Our Ref: EP/85/11/TC
Your Ref:

10th August 2011

Various tree surgery within the Station Road, East Preston Conservation Area
South Eastern Corner of Church and grounds St Mary's Church Station Road/Vicarage Lane
East Preston

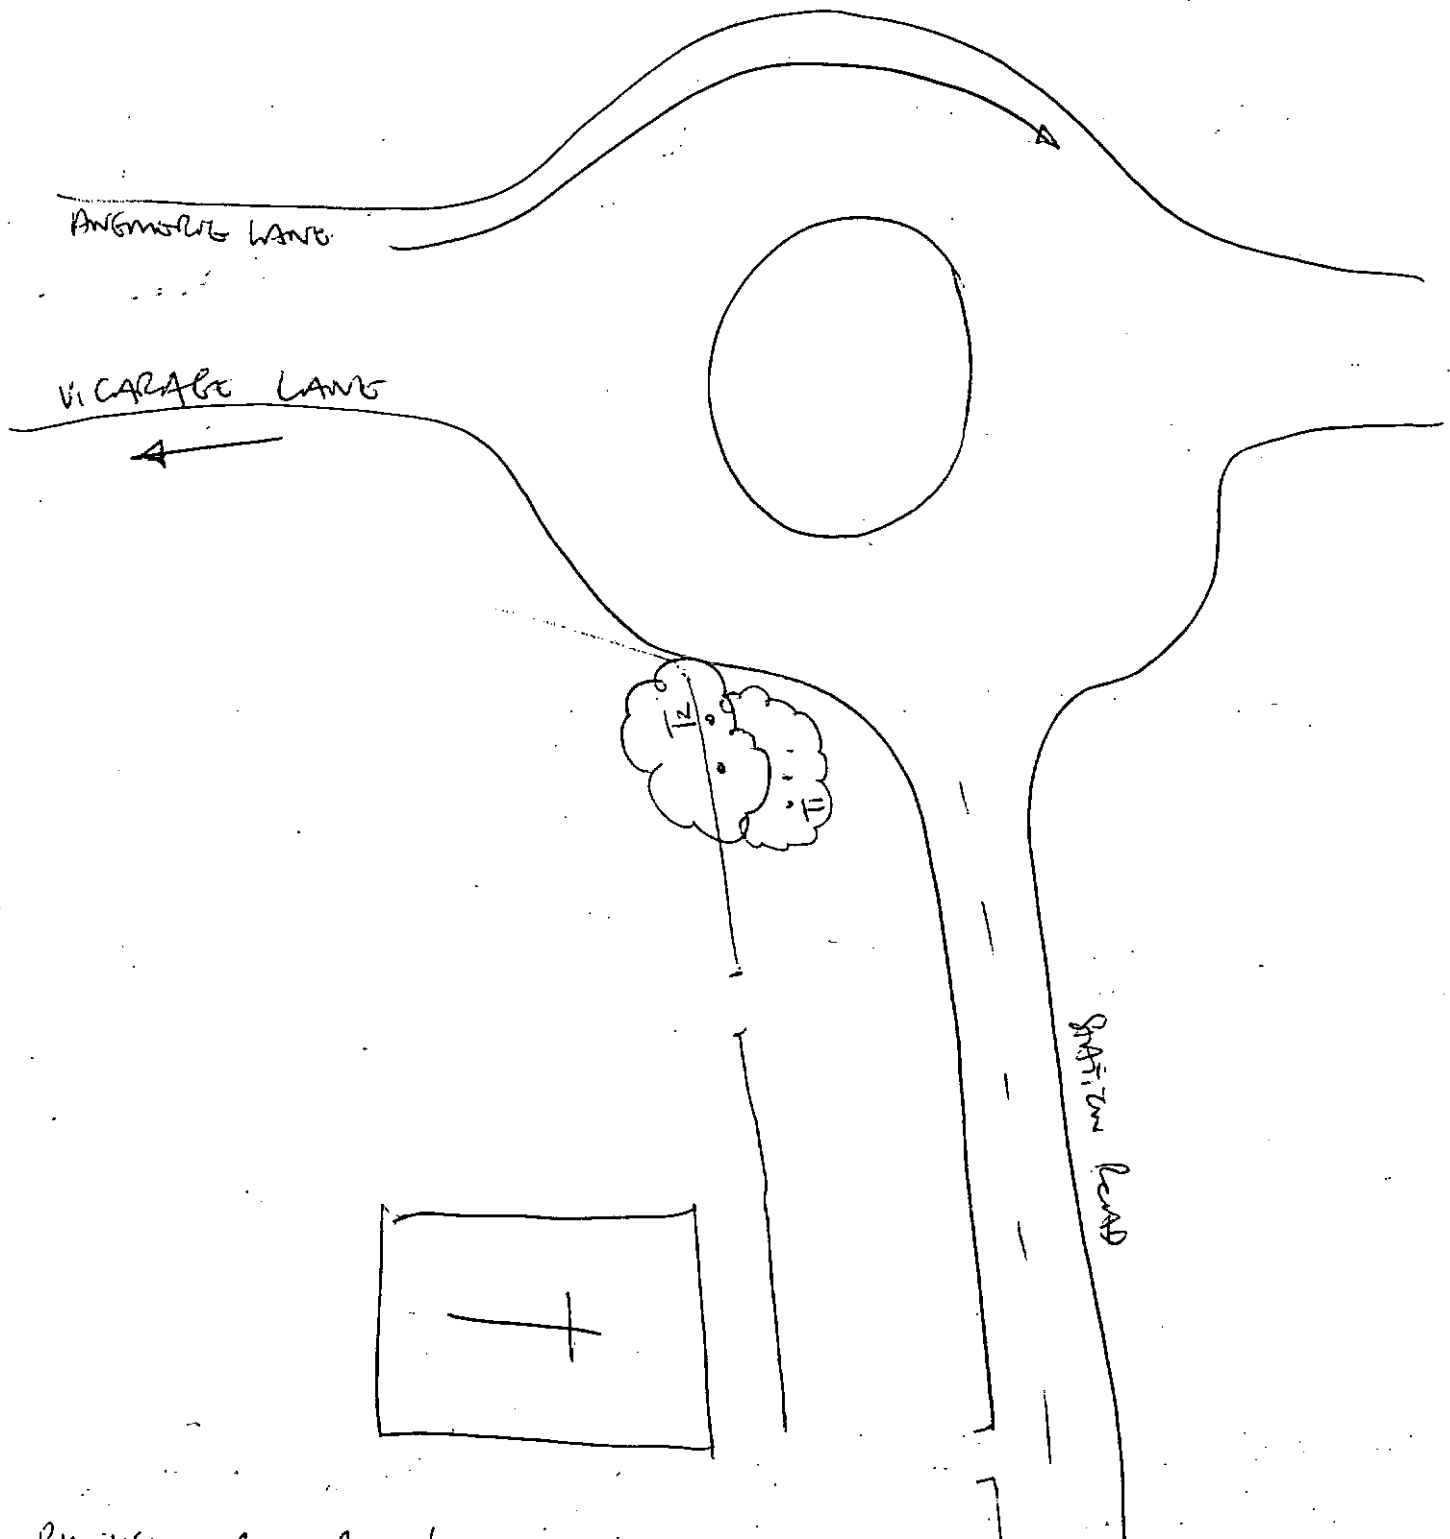
Please clarify T1; is it 2 separate trees (one being an 'Euronymus' and the other a 'Bramble') or one tree, being an 'Euronymus'.

Please confirm the percentage of canopy lift to the Bay tree.
